Subject: Corrimal Coke Works - Stage 2-4 Civil Works (SSD-86131212)

Attachment 1 - CPHR Assessment Summary for Corrimal Coke Works Stage 2-4 Civil Works (SSD-86131212)

Figure 3.2: Stage 2-4 Civil Works Internal Streets

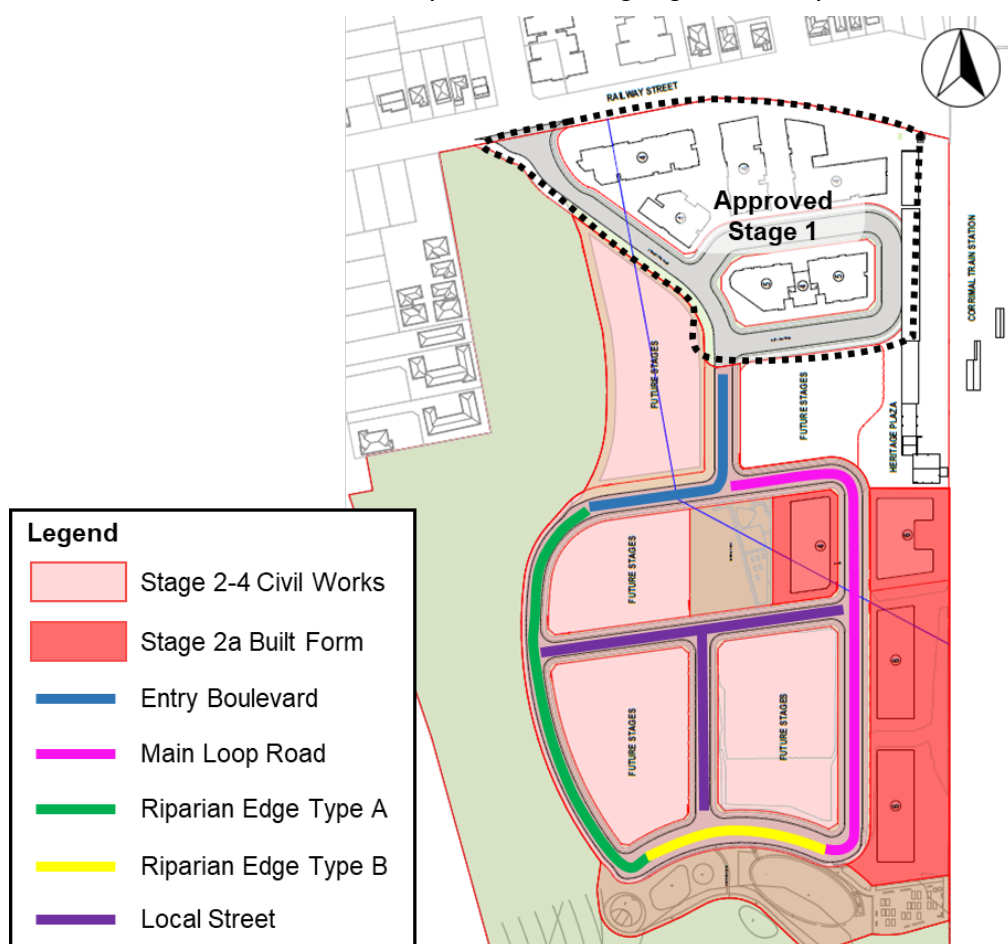
2.	Coastal Management and Riparian	Coastal Management The EIS does not satisfactorily address the following components of SEAR 1 – Statutory Context • <i>Address all relevant legislation, environmental planning instruments (EPIs) (including drafts), plans, policies, guidelines and planning circulars.</i> • <i>Identify compliance with applicable development standards and provide a detailed justification for any non-compliances.</i> The EIS should include considerations of coastal management and potential impacts to the coastal environment. The site is partly located within the coastal zone, including the coastal environment area and coastal use area mapped under Chapter 2 Coastal Management in the <i>Resilience and Hazards State Environmental Planning Policy</i> (RH SEPP). Water from the site will flow into Towradgi Creek estuary and its associated RH SEPP mapped coastal wetlands. In addition, Towradgi Creek is listed as a sensitive estuary under Strategy 11.5 in the <i>Illawarra Shoalhaven Regional Plan</i> (2041). Changes in land use or development in this area has the potential to significantly affect water quality, hydrology, and ecological function within the Towradgi estuary and its wetlands. Recommended action: The proponent should provide further information to demonstrate that the proposal is consistent with Chapter 2 Coastal Management of the RH SEPP, Section 9.1(2) Local Planning Direction 4.2 Coastal Management and Strategy 11.5 of the <i>Illawarra Shoalhaven Regional Plan</i> (2041). Riparian Corridor Encroachment The EIS does not satisfactorily address the following components of SEAR 1 – Statutory Context • <i>Address the requirements of any approvals applying to the site, including any concept approval, any endorsed or draft master plan, precinct plan or any recommendation from Gateway determination.</i> The EIS includes inconsistencies in road layout and potential riparian buffer encroachment. There appears to be inconsistencies between the riparian corridor boundaries and road layouts shown in the Site Context Plans within EIS Appendices I and L and the approved Stage 2–4 Bulk Earthworks plans in Appendix Y. Specifically, the Site Context Plans in the Water Cycle Management Strategy (Appendix I) and the Groundwater Impact Assessment (Appendix L) depict substantially greater road encroachment into the outer riparian buffer between Road 3 and Memorial Drive than is shown in the approved plans (Appendix Y). Recommended Action:

Provide further information to clarify that the road layout in this SSDA is consistent with the approved Stage 2-4 Bulk earthworks DA (DA-2023/823), Councils LEP requirements for riparian lands (Section 7.6) and DCP Chapters E23 and D19.
	<i>Extent and Timing</i>	Pre-determination
